Regarding: Project PR-2019-002496 at Barstow and Alameda NE
Currently scheduled for hearing on 7/17/2019

I respectfully offer the following comments and requests for consideration by the DRB regarding the Site Plan application for the above identified project.

① Phase A-South
1/8" = 1'-0"

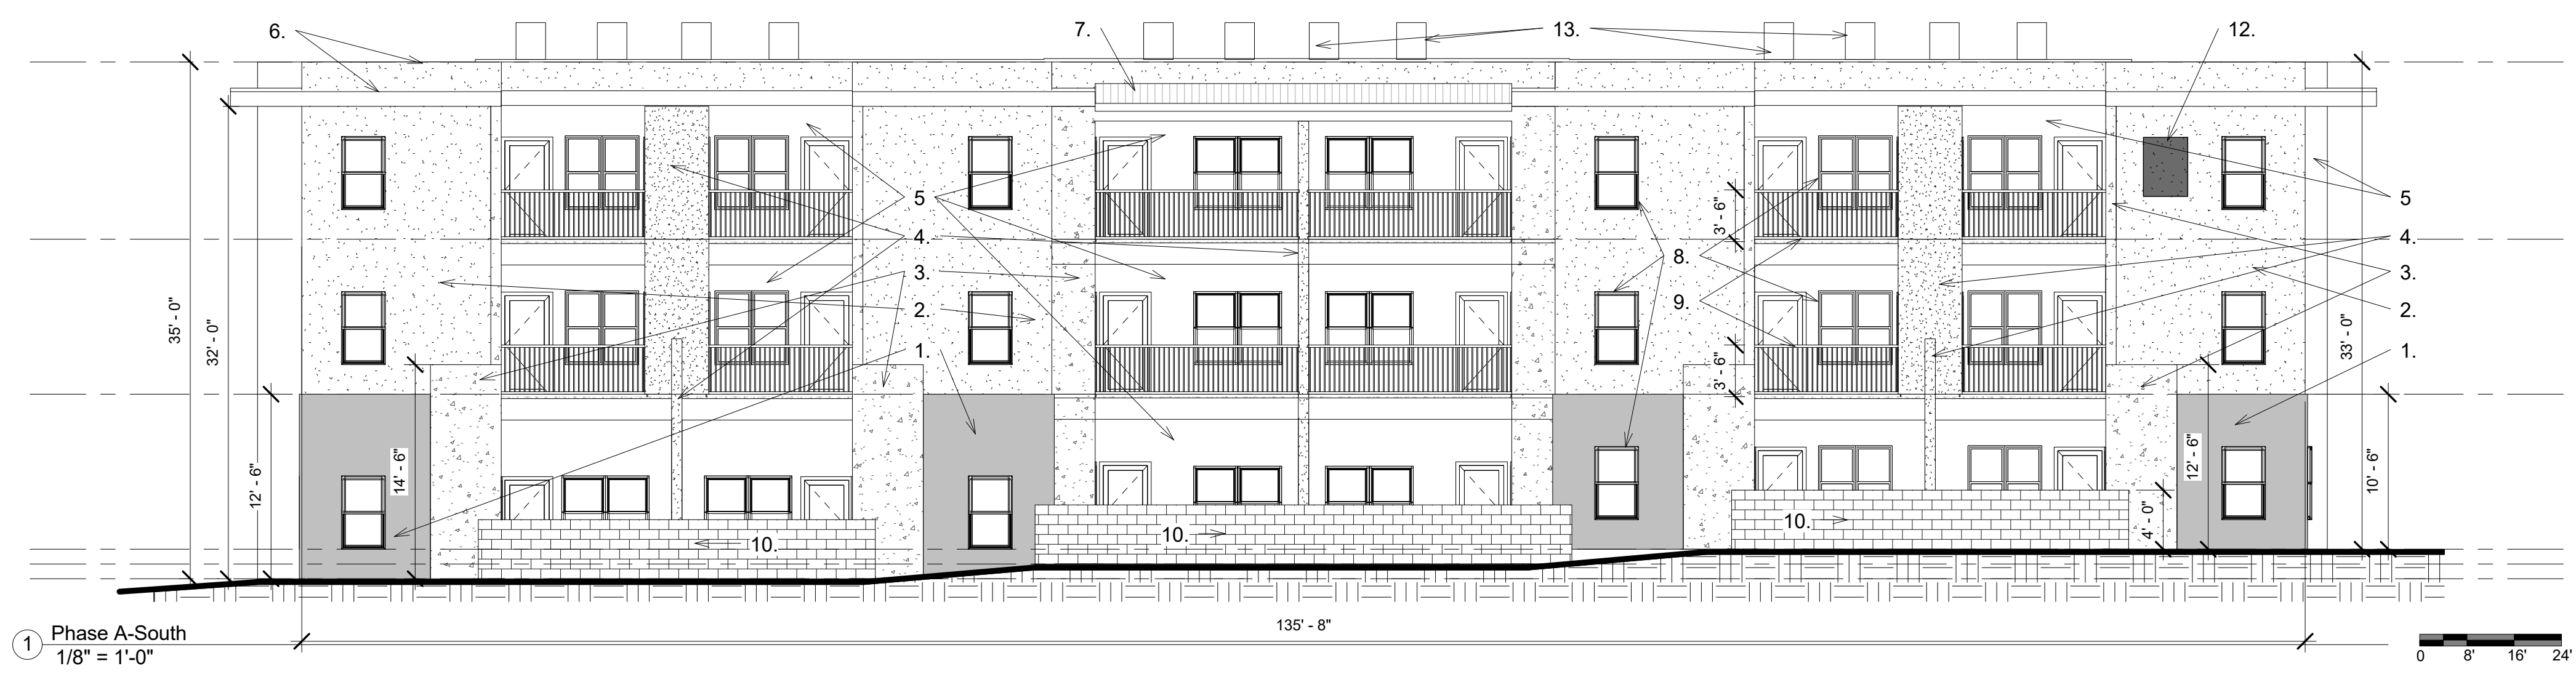
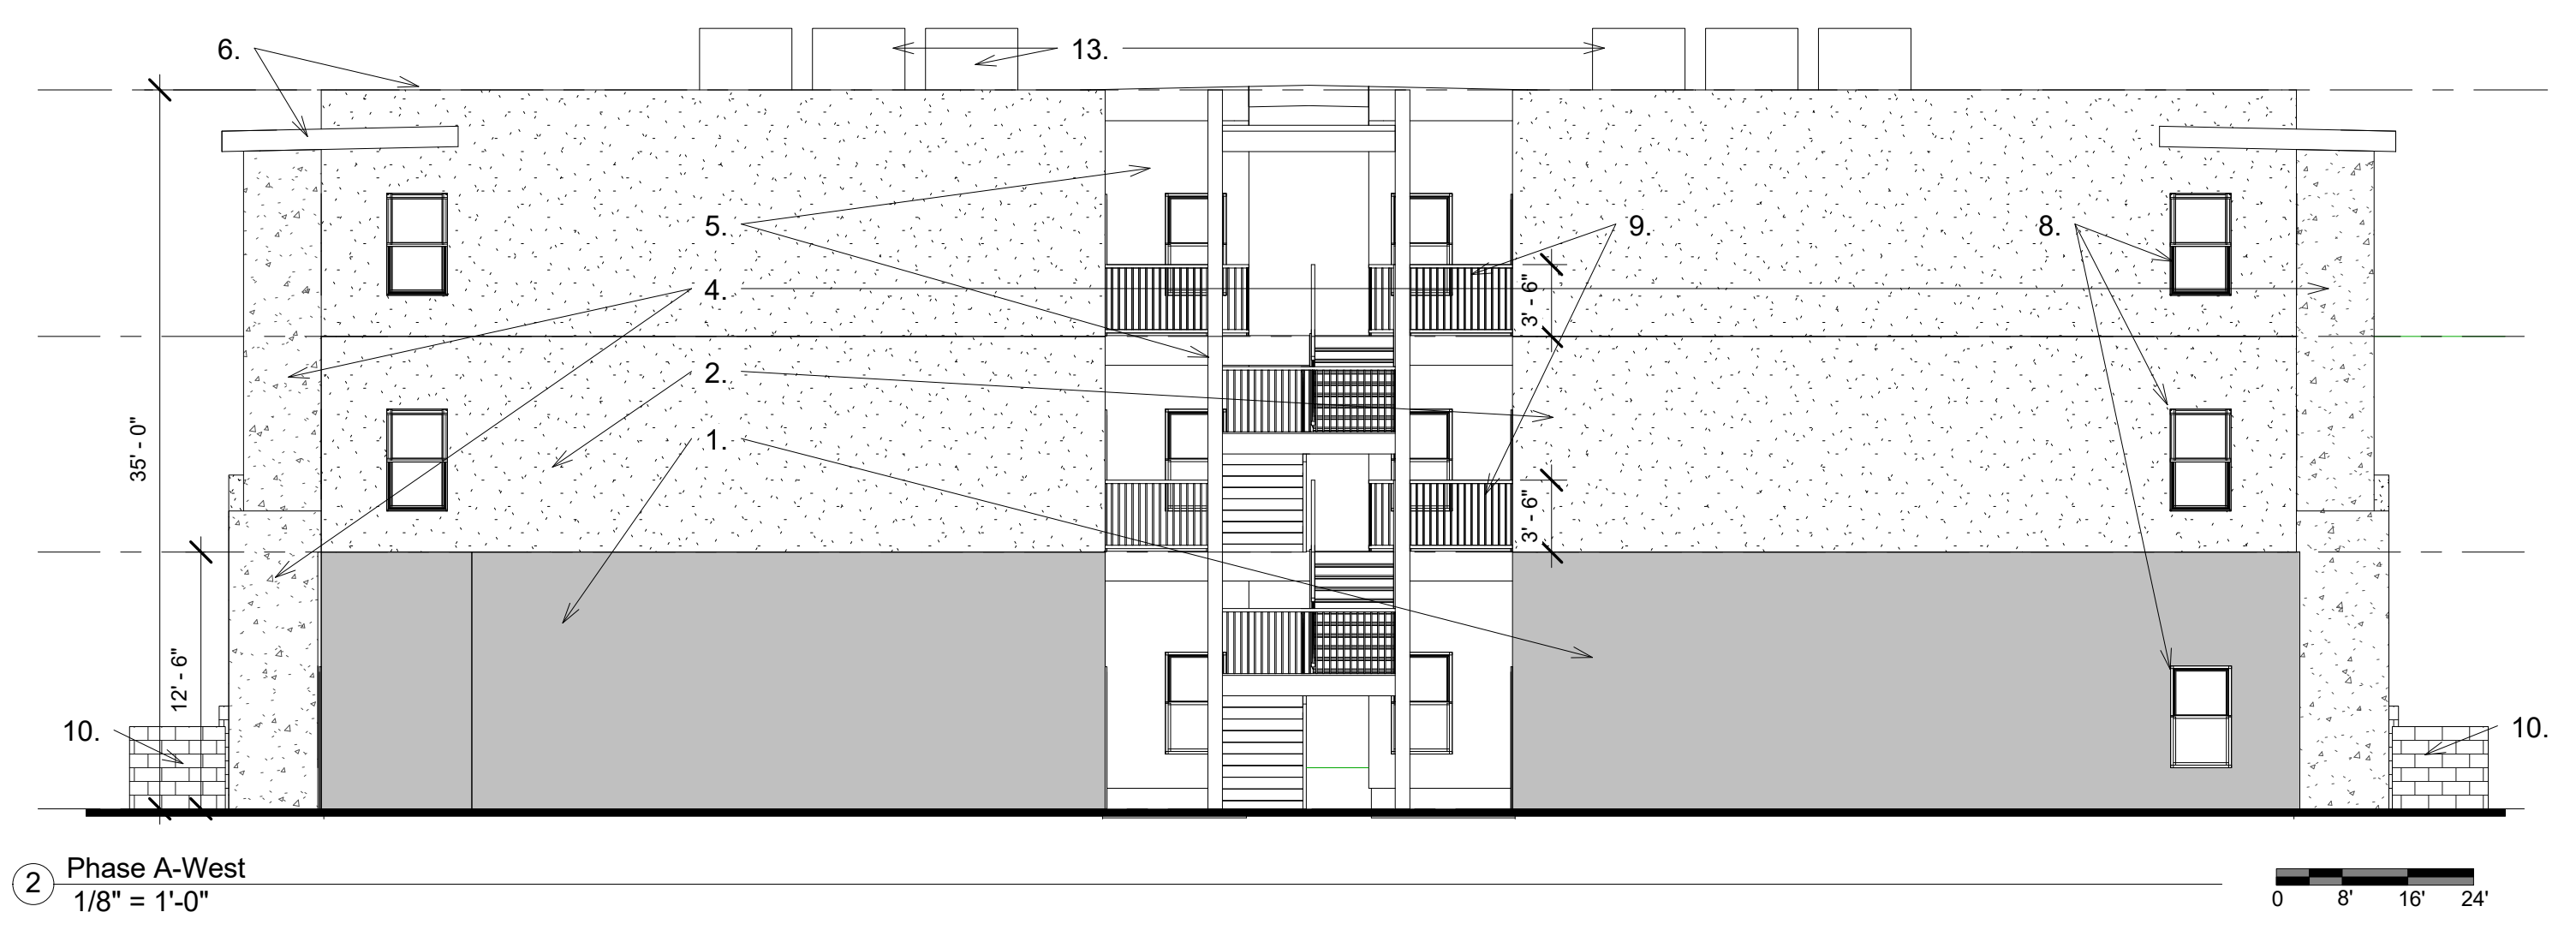
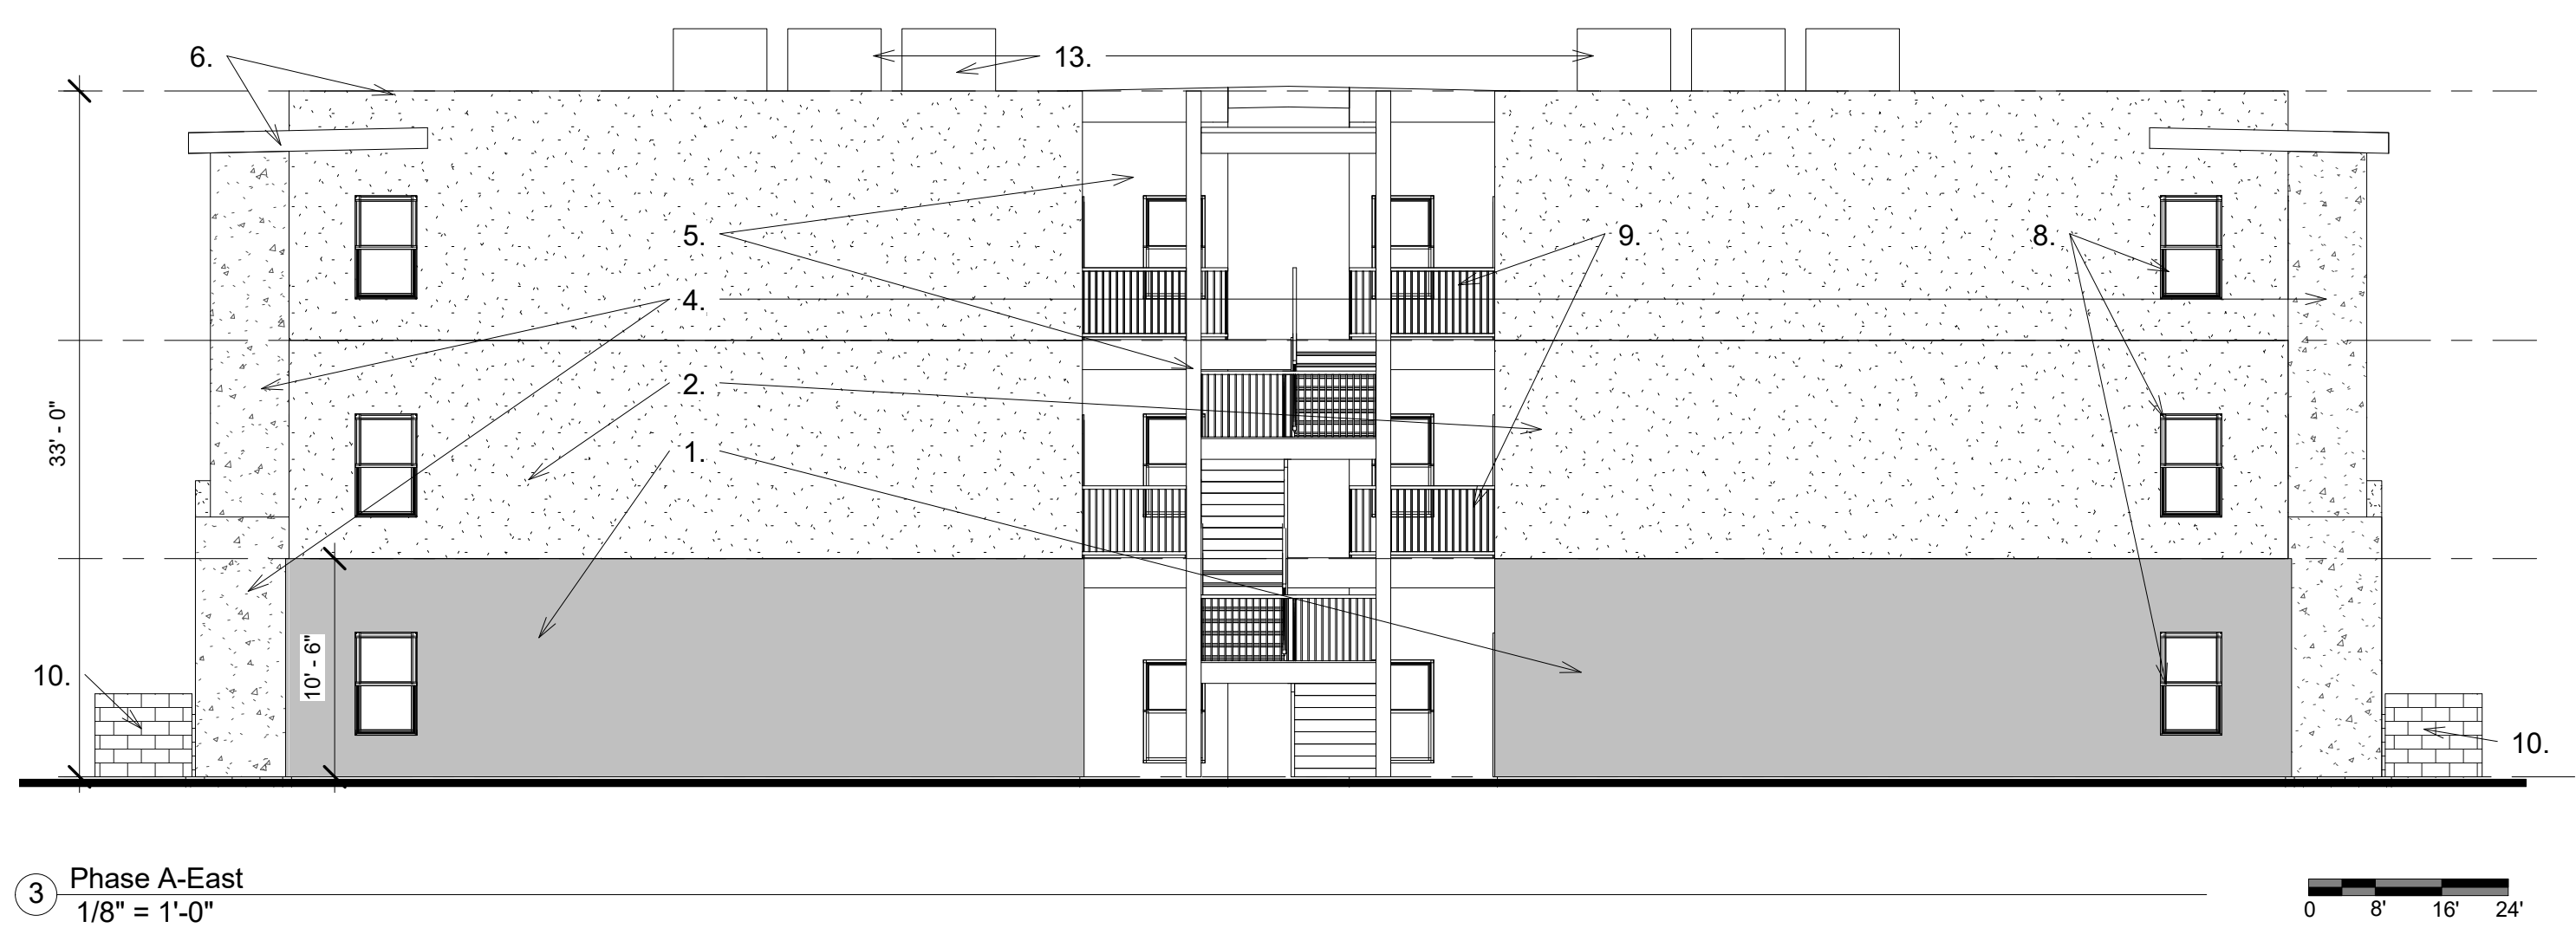
- 4.) 5-6(G)(1)(b) regarding parapet screening of mechanical equipment. While the placement of the A/C – Heat pump equipment toward the center of the building might preclude the need for additional screening for street level line of site requirements, it might still be desirable for screening the equipment from sight and noise from the second floor of the homes to the south. 93 A/C compressors and condenser fans, no matter how quiet individually, has potential for being more than just a minor annoyance.

- 5.) 5-11(E)(2)(a)(1) regarding Ground Floor architecturally distinctive from upper floors. Color is the only thing we see that distinguishes the first floor from upper floors and question if that is sufficient.
- 6.) 5-11(E)(2)(a)(2) regarding façade features along public street – It sure does not appear that the Barstow side façade (Phase A west elevation) design meets this requirement but if it does, the requirement is insufficient. The current design does not provide a very attractive presentation to Barstow and Alameda intersection traffic and to adjacent property owners.
